**EL PASO COUNTY PLANNING AND
 COMMUNITY DEVELOPMENT
 DEPARTMENT**

GRADING AND EROSION CONTROL PLAN CHECKLIST

Revised: July 2019

GRADING & EROSION CONTROL PLAN

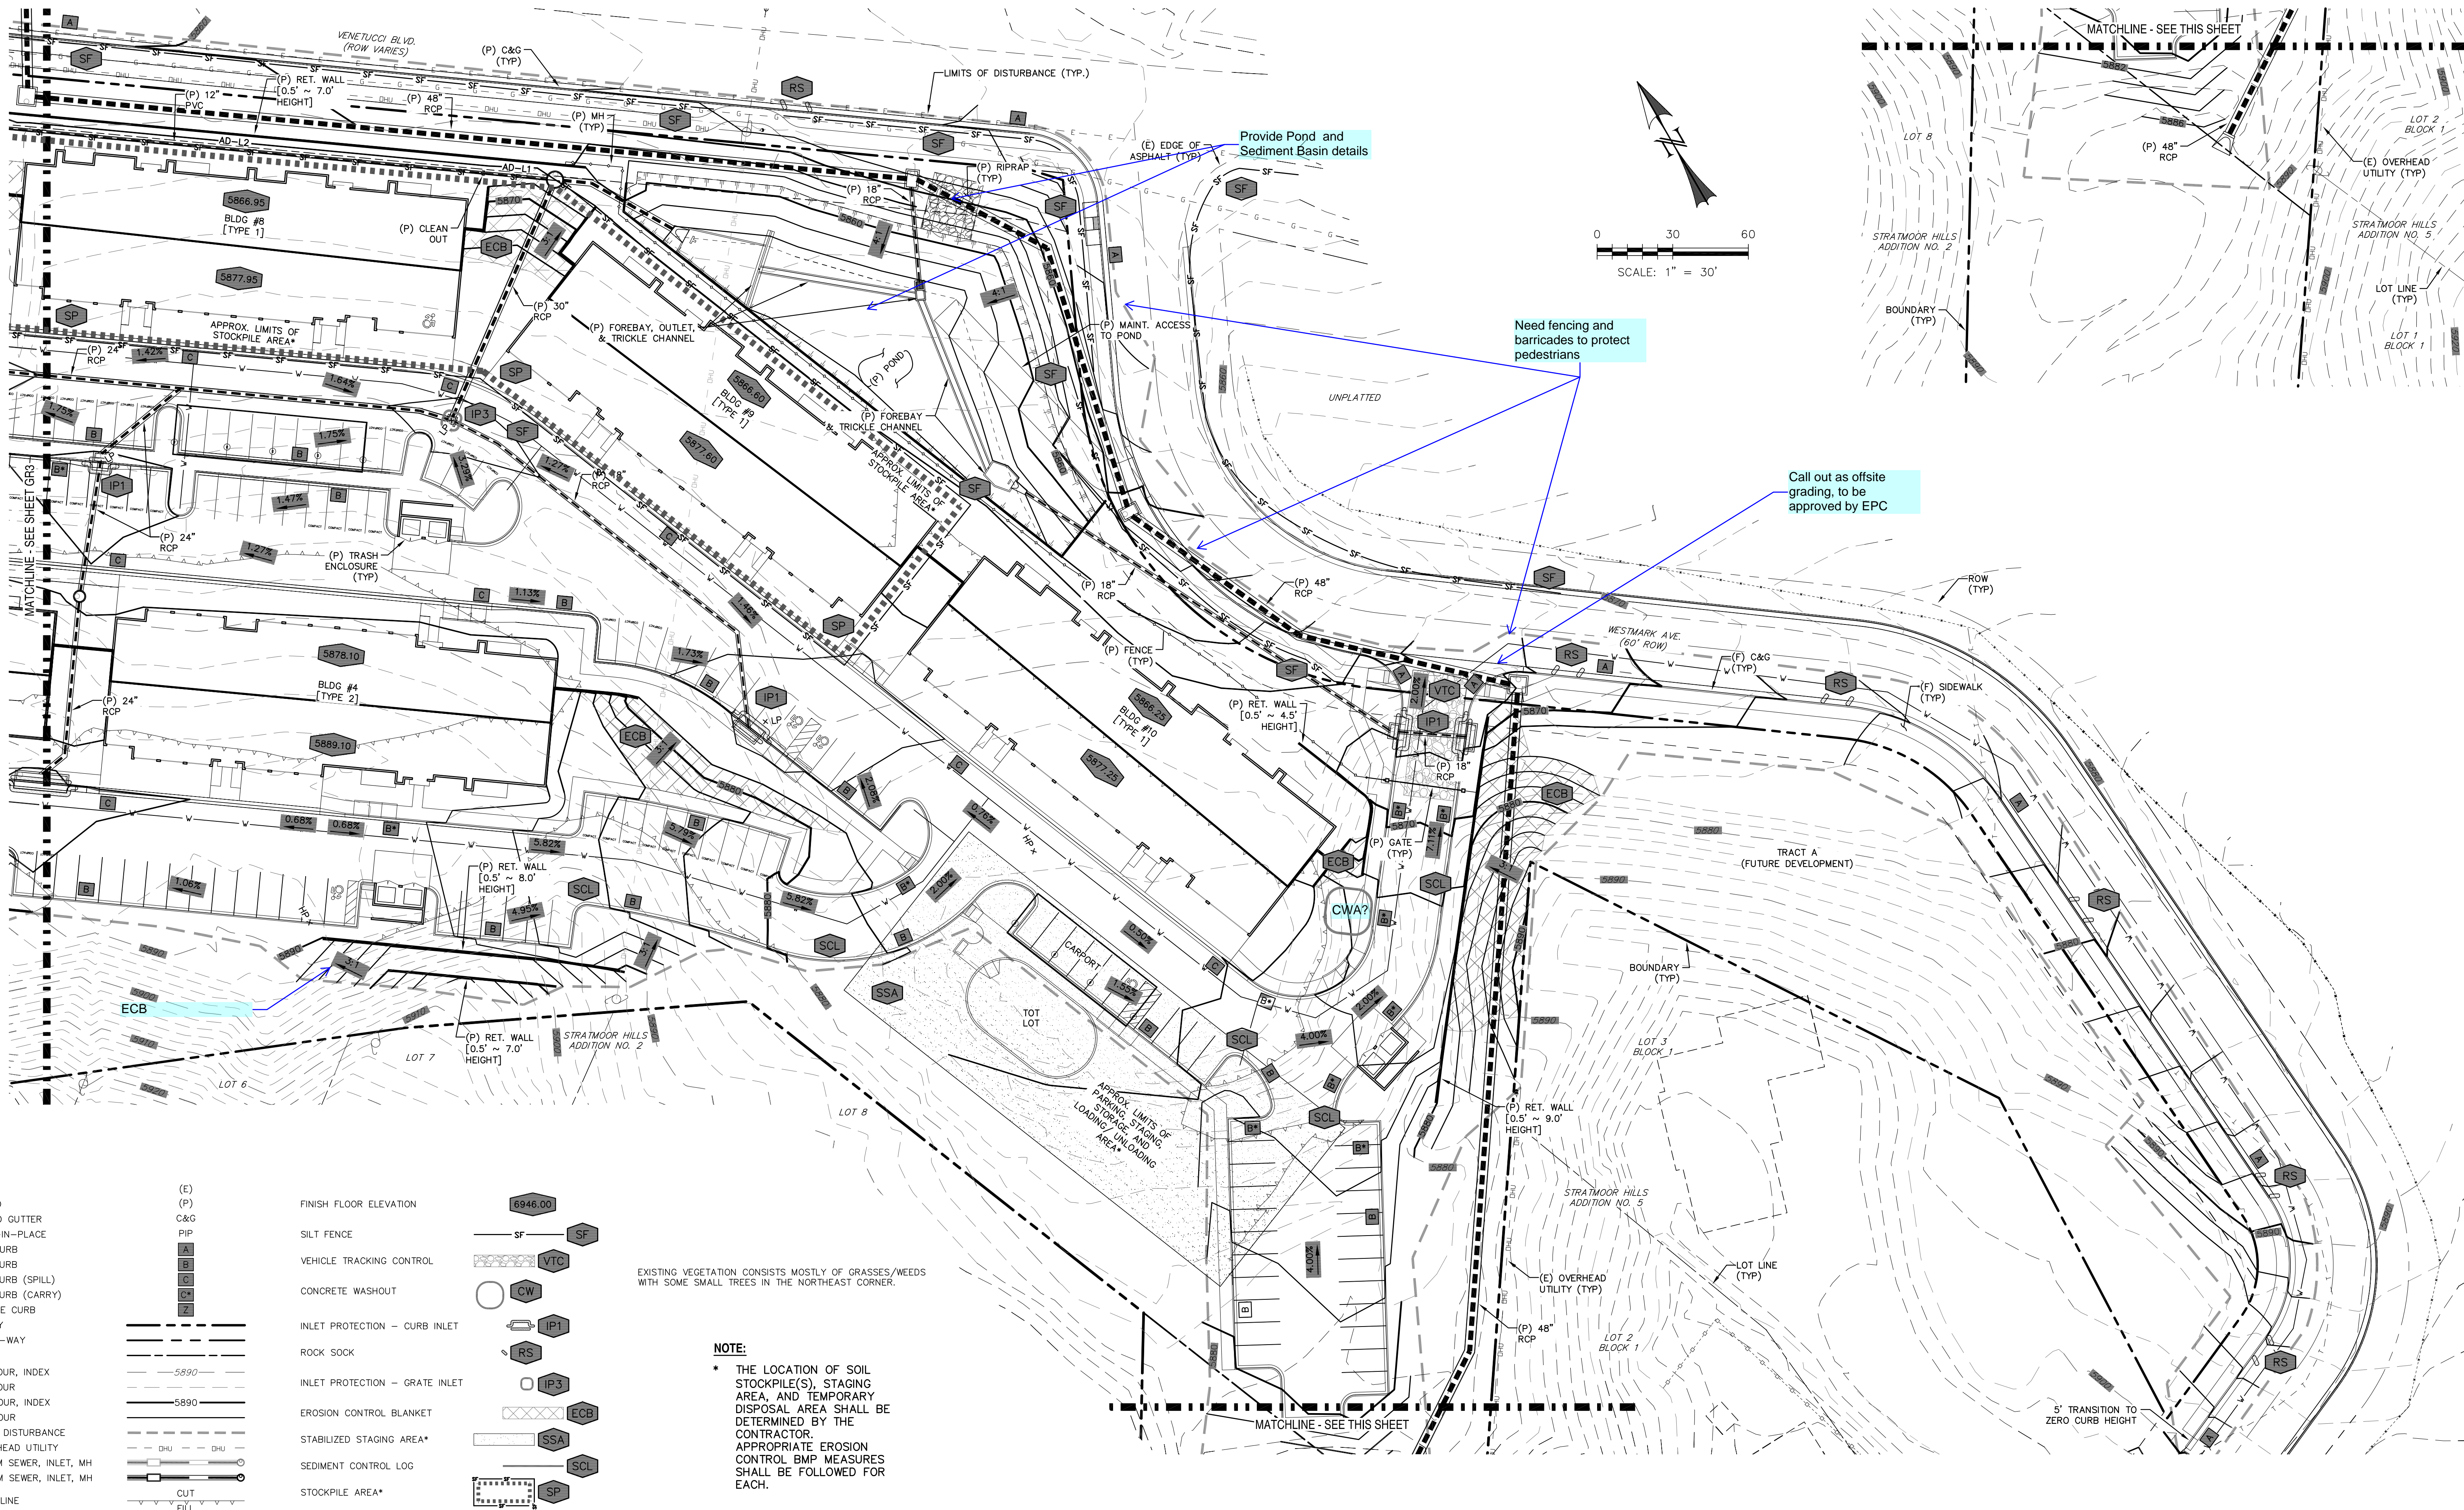
m	Limits of disturbance delineating all anticipated areas of soil disturbance.	X	✓
n	Identify and protect areas outside of the construction site boundary with existing fencing, construction fencing or other methods as appropriate.	N/A	X
o	Offsite grading clearly shown and called out.	X	X
p	Areas of cut and fill identified.	X	✓
q	Conclusions from soils/geotechnical report and geology (slopes, embankments, materials, mitigation, etc.)	X	✓
r	Proposed slopes steeper than 3:1 with top armor and protective covering required.	N/A	X
s	Stormwater flow direction arrows.	X	X
t	Location of any dedicated asphalt / concrete	N/A	N/A
u	Areas used for staging, storage of building materials, soils (stockpiles) or wastes. The use of construction office trailers requires PCD permitting.	X	✓
v	All proposed temporary construction control measures, structural and non-structural. Temporary construction control measures shall be identified by phase of implementation to include "initial," "interim," and "final" or shown on separate sheet.	X	X

w	Vehicle tracking provided at all access points and signage provided at access points not to be used for construction.	X	✓
x	Temporary sedimentation ponds.	X	X
y	Dewatering operation design.	N/A	N/A
z	All proposed temporary construction control measure details. Custom or other jurisdiction's details used must meet or exceed EPC standards.	X	X

Only off-site is curb & gutter on public streets. We show silt fence, inlet protection, and rock socks in public streets.

Site boundary shown, limits of construction shown, and contours show extent of grading.

There are no slopes steeper than 3:1. Blanketing shown on the plan.

Slope arrows shown on plan.

Measures broken into stages, described with notes, and stage labels added to legend.

Note added for permanent ponds to be used as temp. sediment ponds during construction.
